## **Cawston Parish Council, Confirmatory Points following Issue Specific Hearing 3, Norfolk Boreas Inquiry, Deadline 4 Submission**

Cawston PC wishes to make the following submission for Deadline 4. This includes confirmation of points raised in oral evidence at the Hearing on 21<sup>st</sup> January.

CAWSTON HIGH STREET - INTERVENTION SCHEME  
Scale 1:500

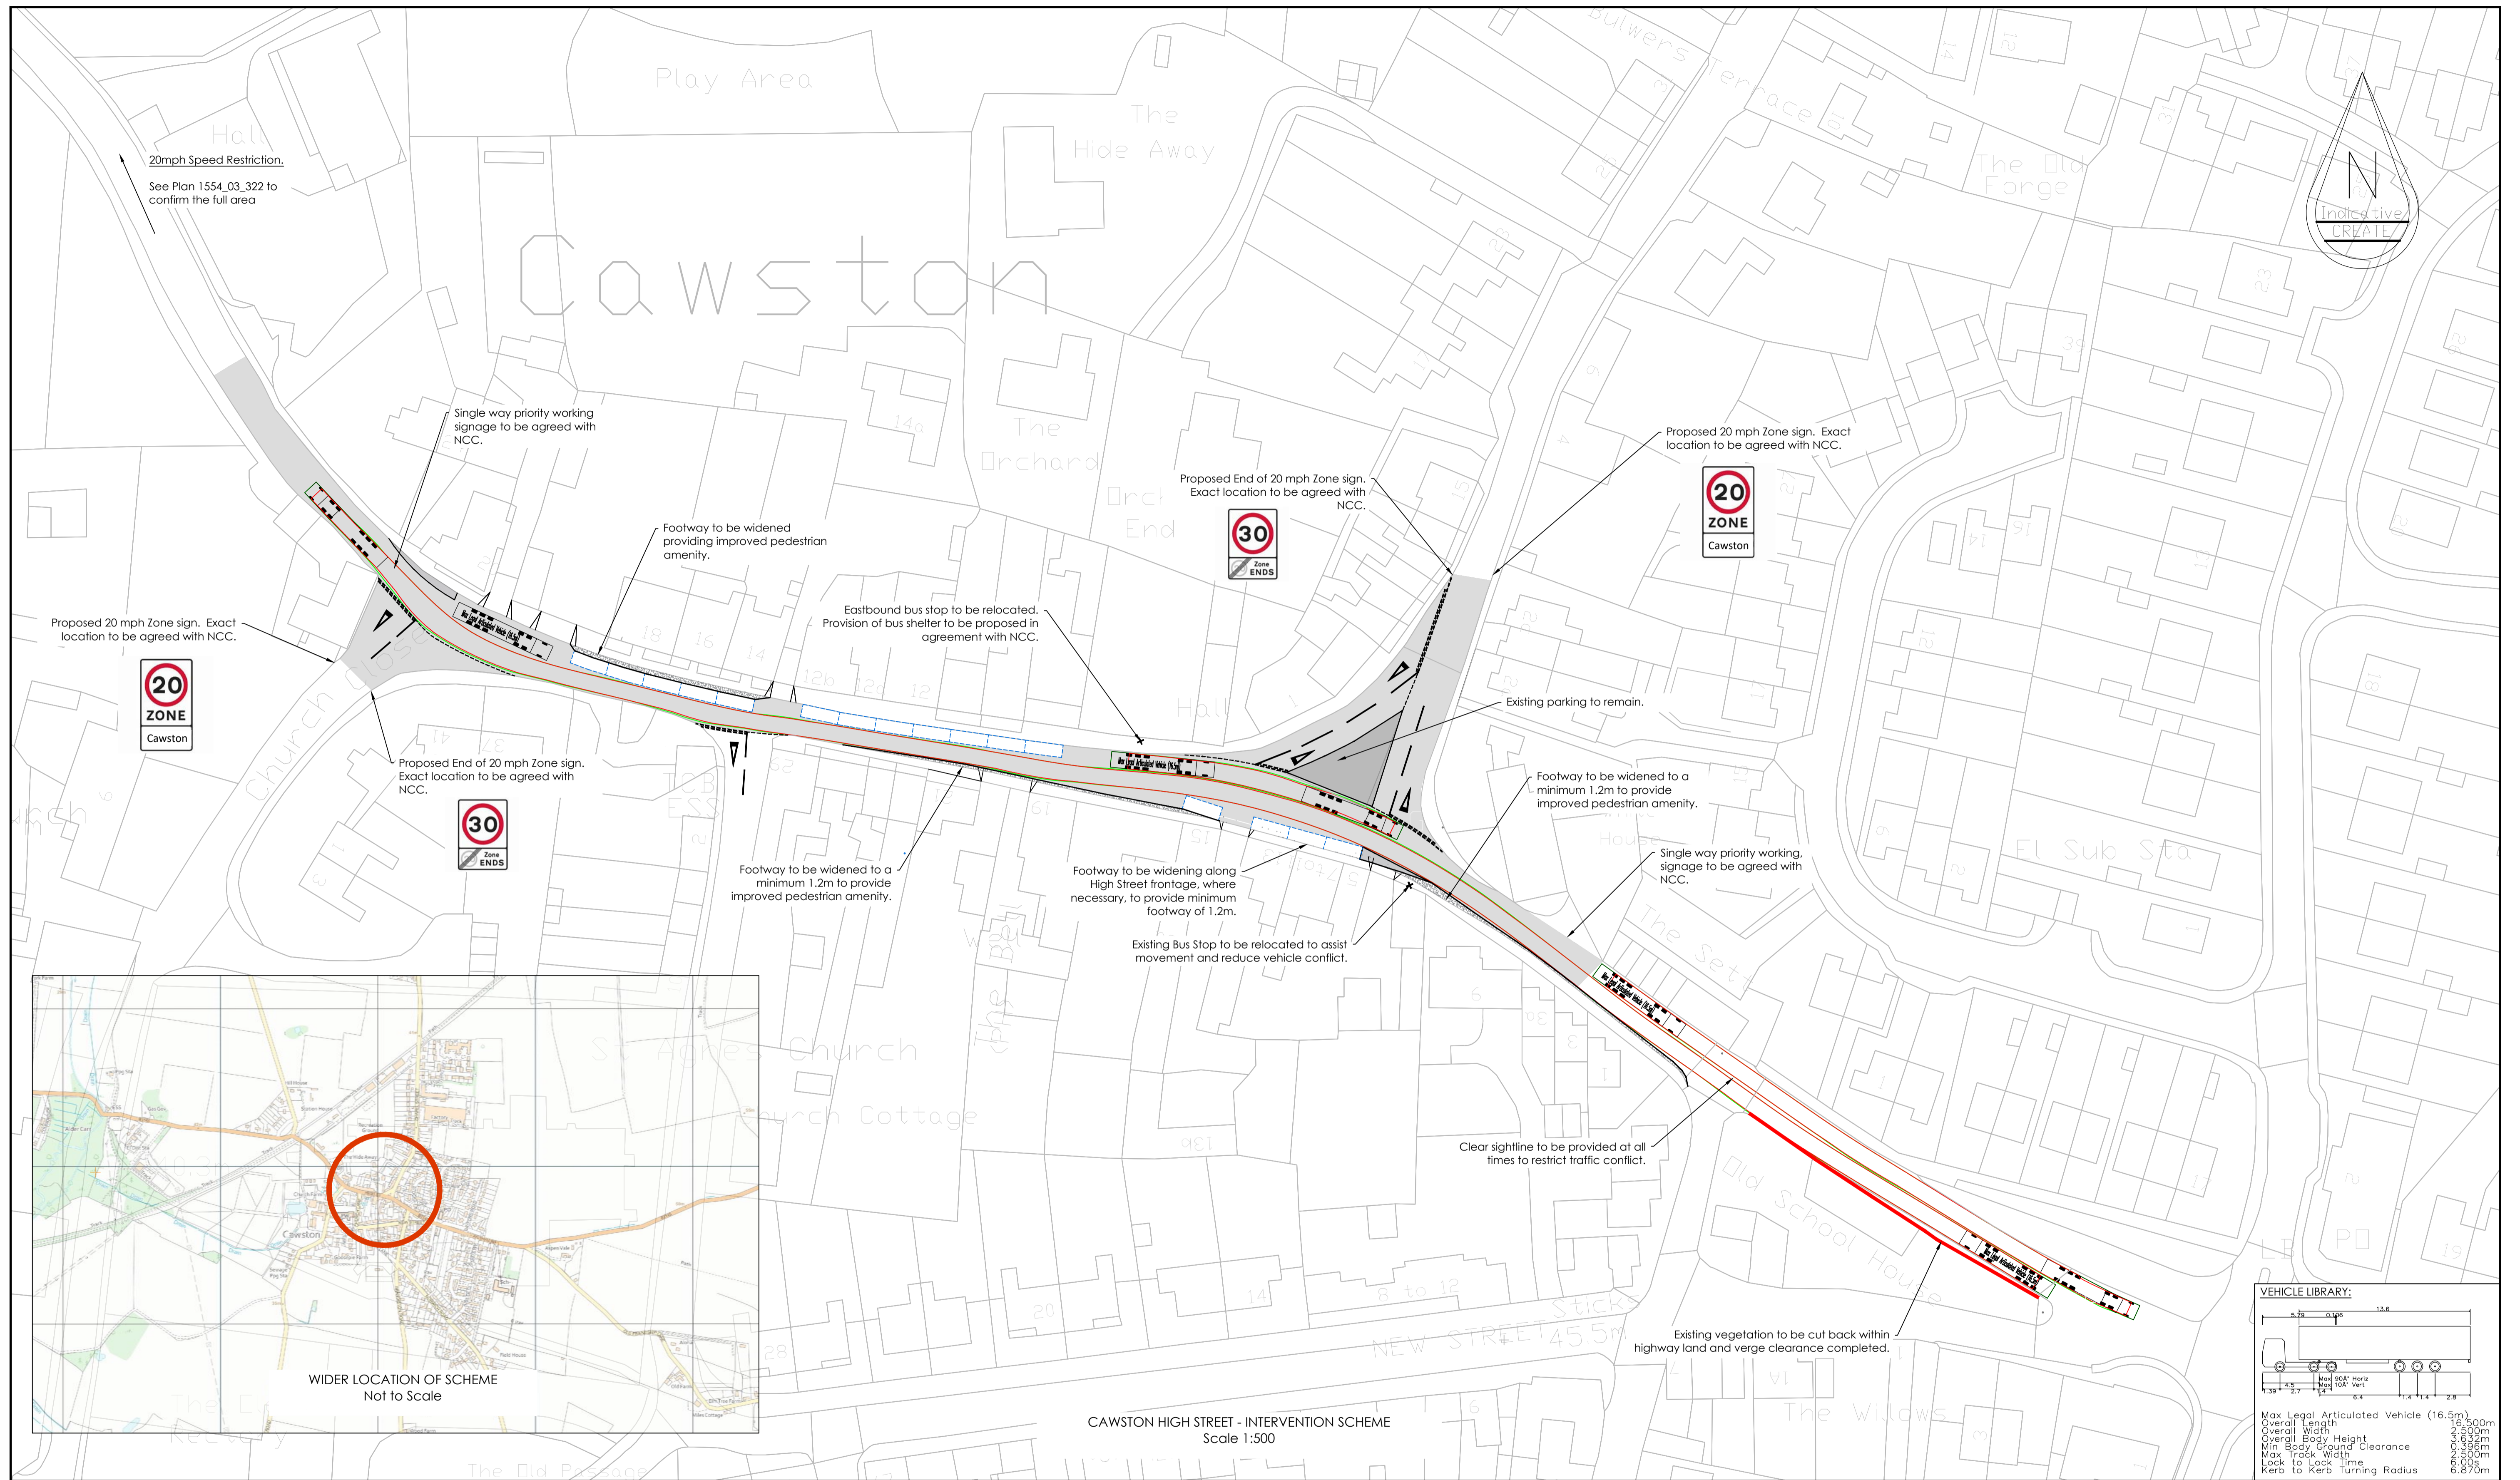
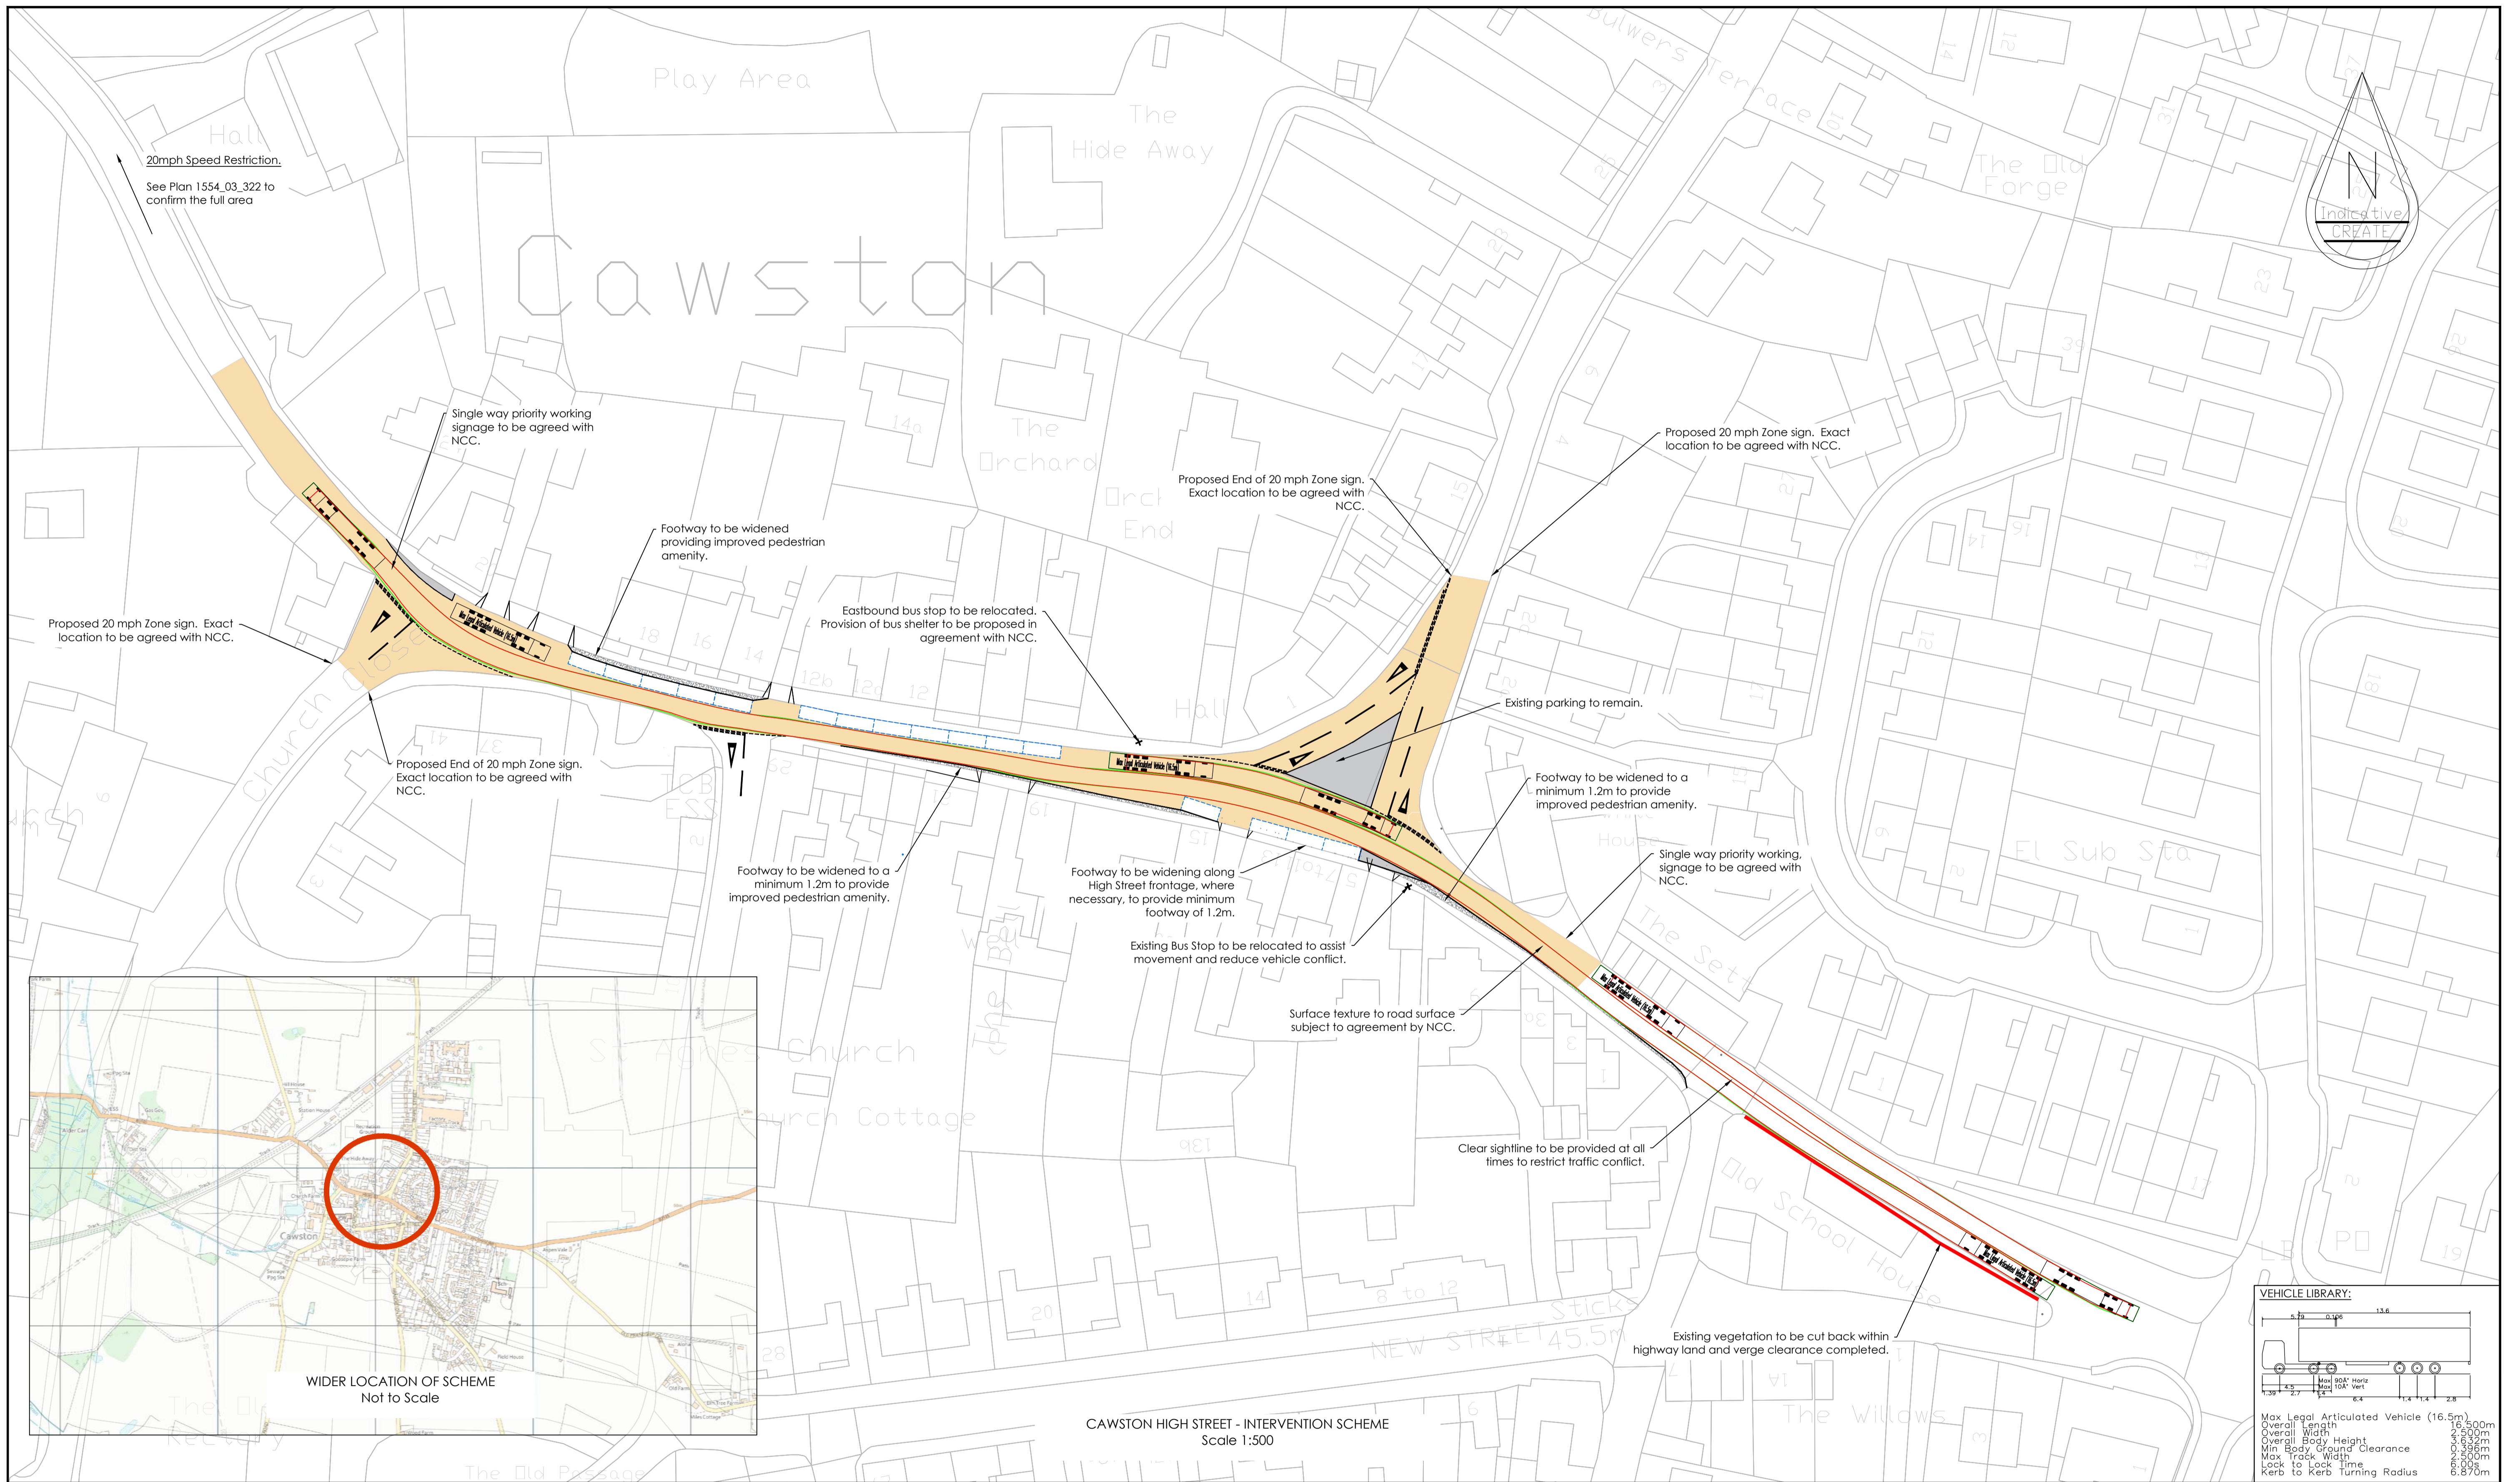
Our D2 submission asked for a definitive and unambiguous up to date Highway Intervention Scheme (HIS) for Cawston. Instead we were faced at the Hearing with the Hornsea 3 version from May 2019 which had already been examined (twice), failed a Road Safety Audit and been generally rejected by all parties. Similarly, the Applicant offered a Hornsea 3 report on Noise & Vibration which is a year old, which has been examined before and yet was presented with no acknowledgement of the critiques and caveats previously discussed.

We understand that any study of noise and vibration issues cannot be properly considered until a final HIS is agreed with NCC. For example, we believe that the width of the footpath will be an important factor; at the time the Hornsea 3 report was carried out the HIS rested on widening footpaths significantly to improve pedestrian safety. We also believe there will be issues arising from traffic speeds and/or traffic pulling away from being stationary in the inevitable gridlocks if passing places are introduced.
